Robert Alvarez Vacation, VA-17-001

Please accept the following comments from El Paso County Public Health for the interior lot line vacation request referenced above:

PILOT PLAN
Robert Alvarez

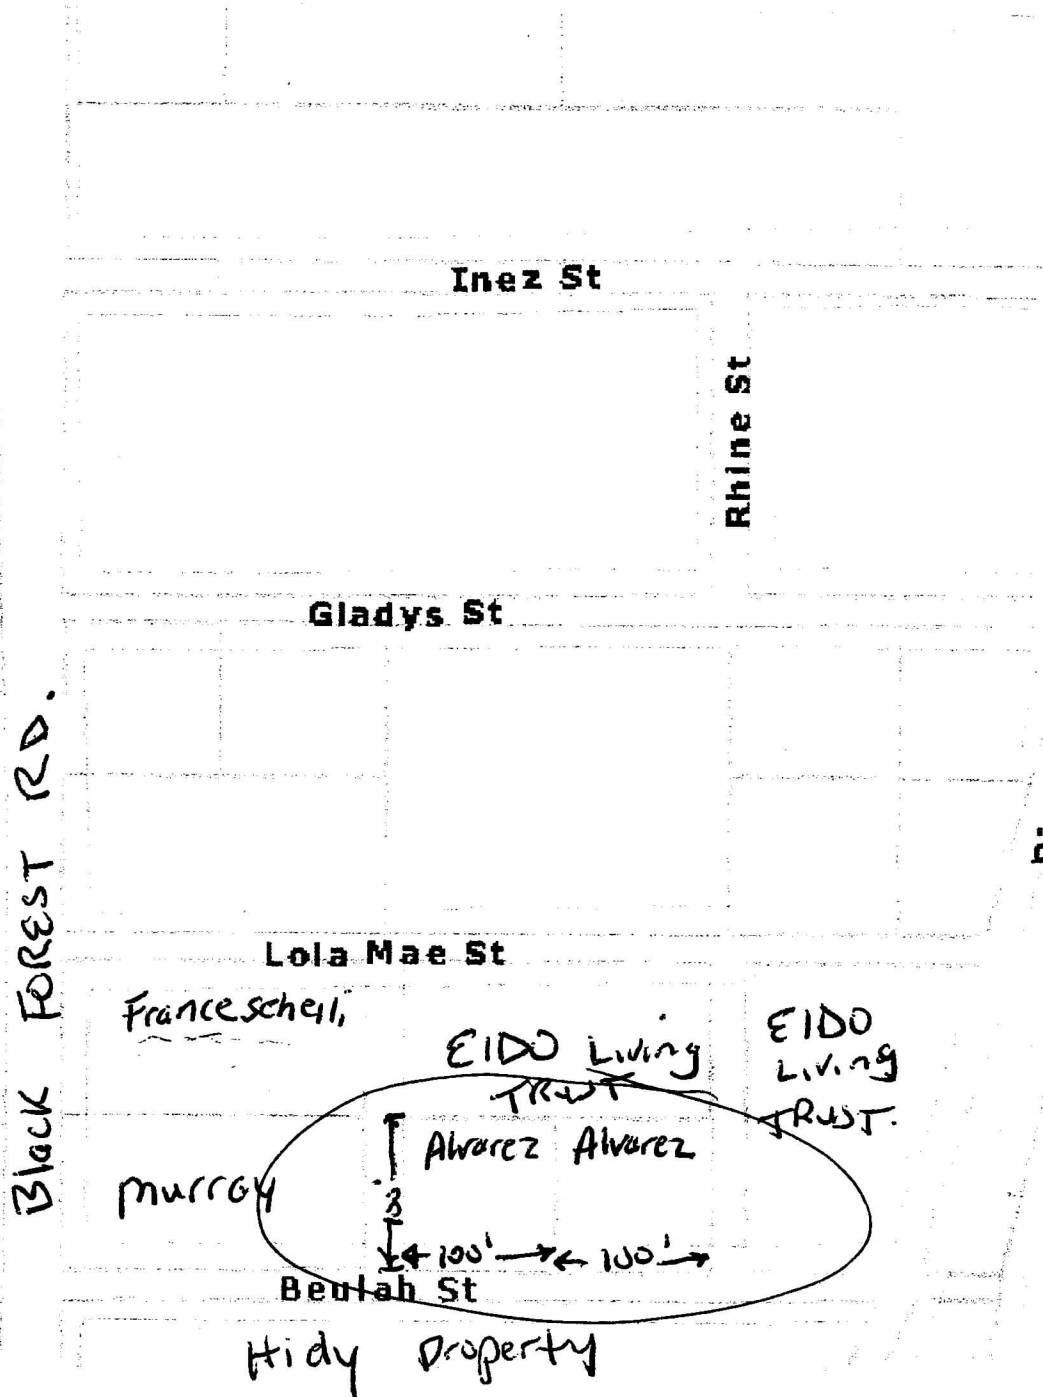
- **Drinking water for the proposed residence will be provided by an individual private well. The location of this proposed well on the ½ acre lot is critical to approval of this request. The well must be 100' minimum from the closest portion of the proposed soil treatment area *and* the secondary area required by regulation for a replacement soil treatment area if the primary soil treatment area were to fail in the future.**

- **Wastewater service for the project is proposed to be an on-site wastewater treatment system (OWTS). The results of the soil profile test pit evaluation and the number of bedrooms proposed for the house determine the size of the soil treatment area. Locating the OWTS, the house, driveway, and the well have to be planned accurately for this small lot to be developed to the current OWTS Regulations. It is encouraged to have soil test information prior to proceeding to the BoCC Hearing. Please contact El Paso County Public Health if you are interested in meeting one of our OWTS specialists on site.**

- **Precautions such as fencing, or staking around the proposed soil treatment area should be taken to protect it from compaction by vehicular traffic, parking, and construction equipment. Compaction of the soil treatment area may lead to pre-mature failure of the soil treatment area, and possibly having to relocate the soil treatment area(s).**
